Our Ref: 718742  
DPIE Ref: DA220-07-2002-I-Mod-12  
RFI Ref: RFI-35384212

**RESPONSE TO REQUEST FOR ADDITIONAL INFORMATION – MODIFICATION TO DEVELOPMENT CONSENT  
DA220-07-2002-I-Mod12, 1 DAMPIER STREET, BOWMAN NSW**

On behalf of the applicant, Teys Australia Southern Pty Ltd, please find below a formal response to the request for additional information provided by the Department on 01 February 2022. The below response adopts the points outlined within Attachment 1 of the request.

00A201 - 1
NOT FOR CONSTRUCTION

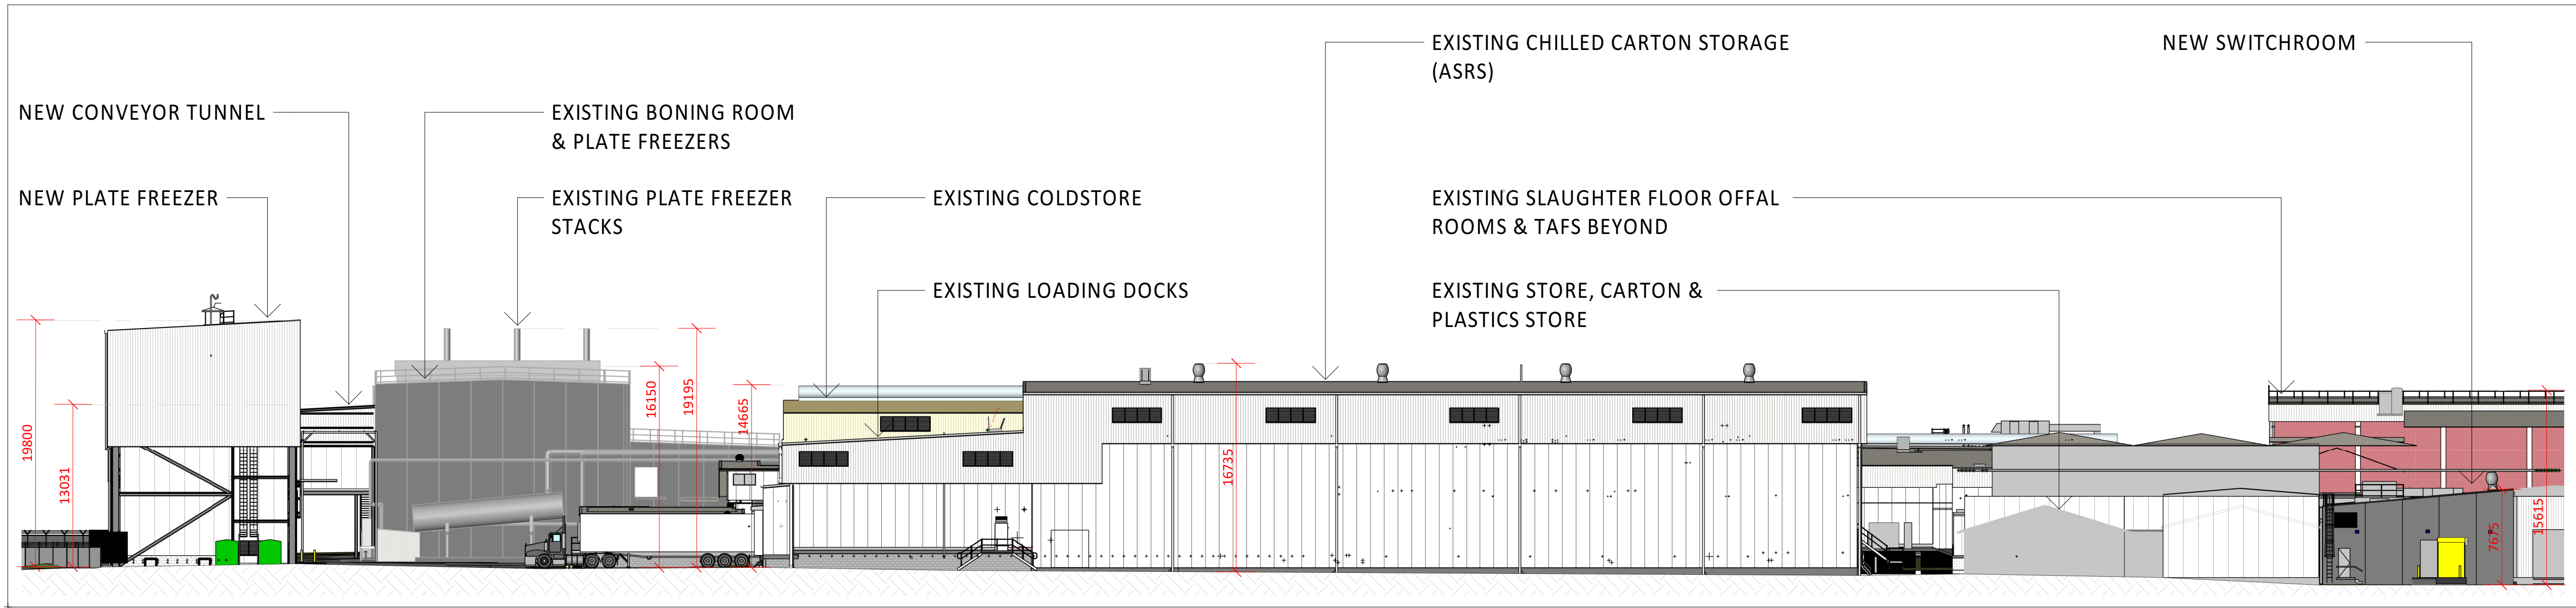
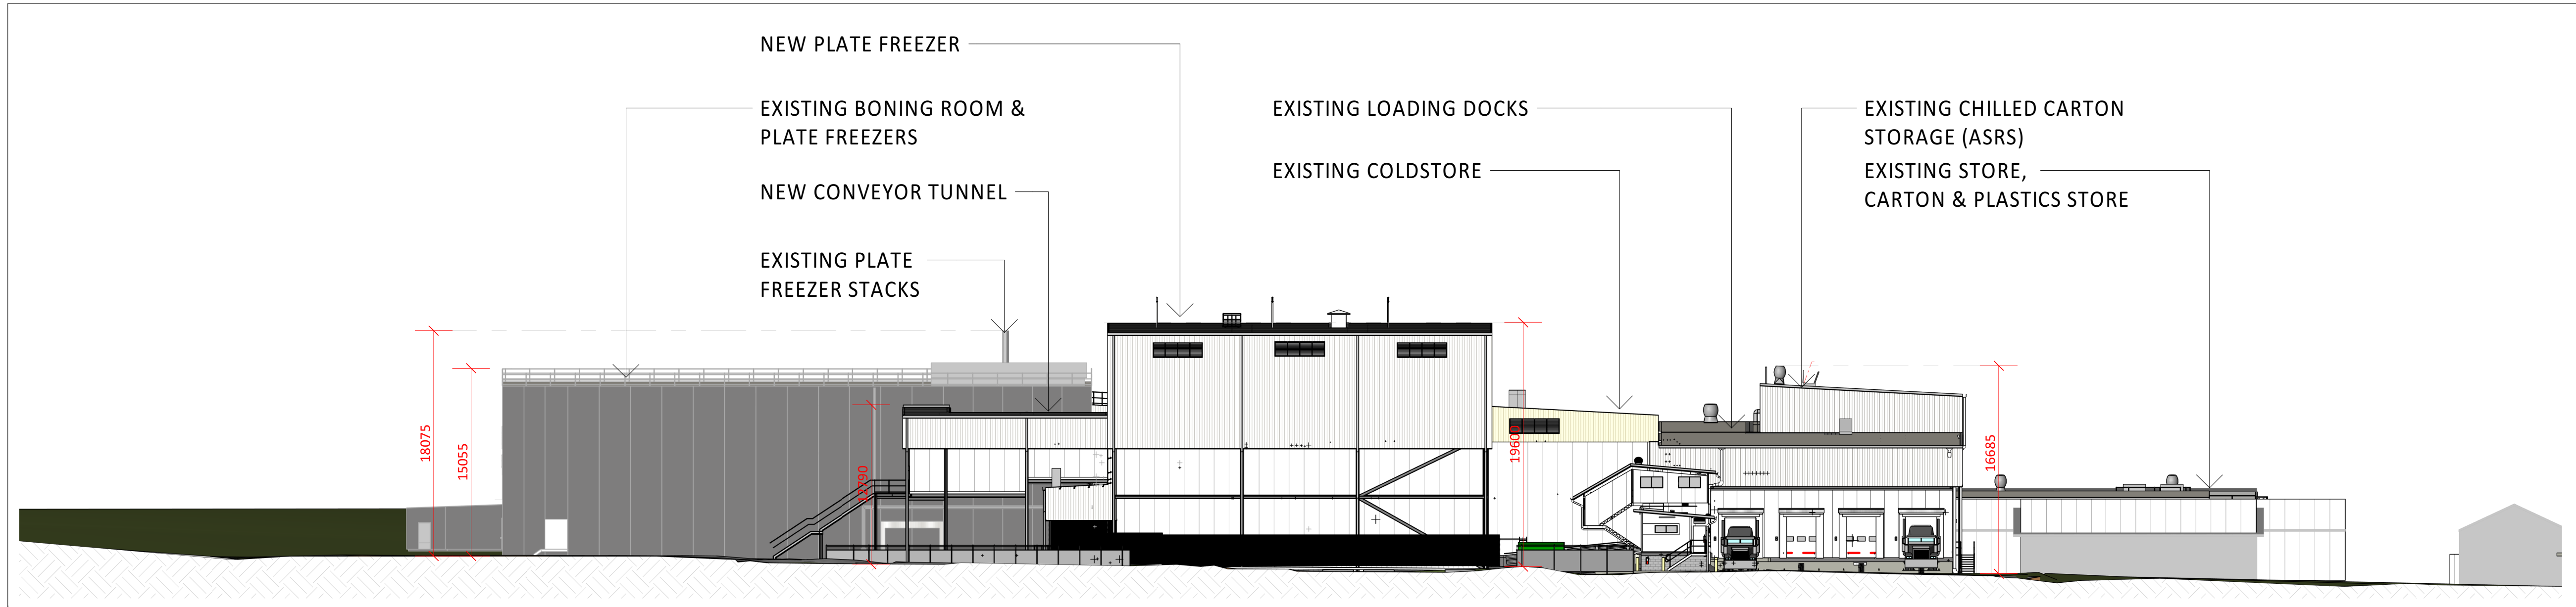
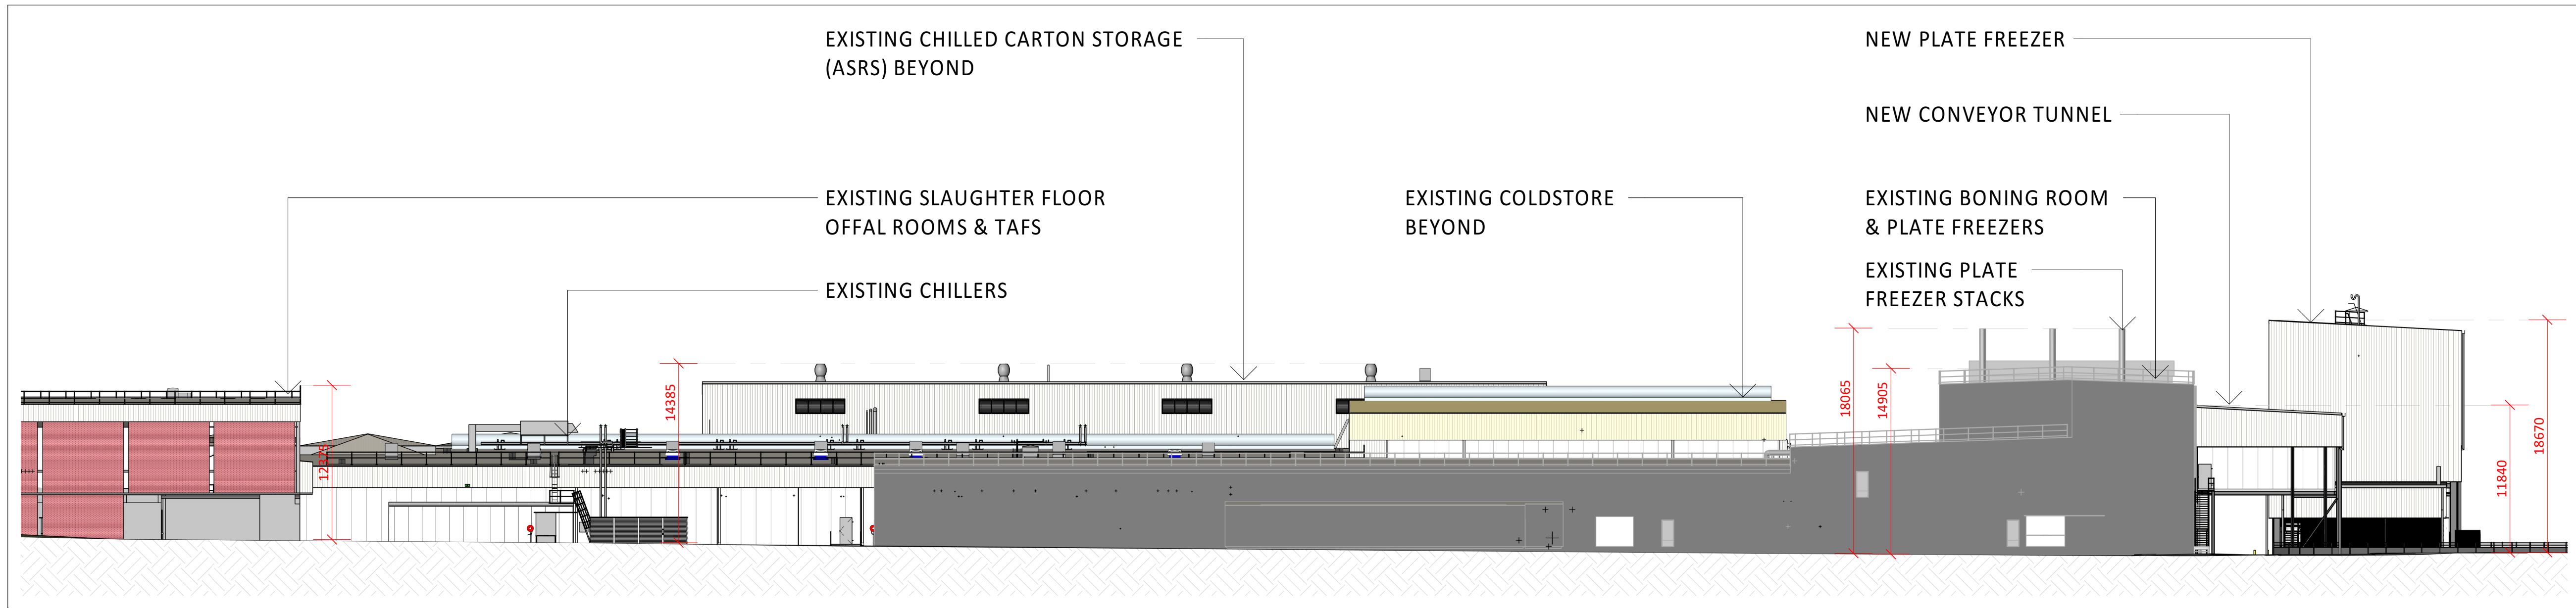
No annotated RL levels at the maximum building height of the proposed buildings are provided. Additional RL levels for the proposed works and the surrounding existing buildings are to be annotated. This is particularly important in order to establish the relationship between the proposed buildings and the existing on-site structures, and to help the Department accurately determine any perceived or actual amenity impacts the proposed works will have on the surrounding area.

Elevation Plans have been provided to provide further clarification.
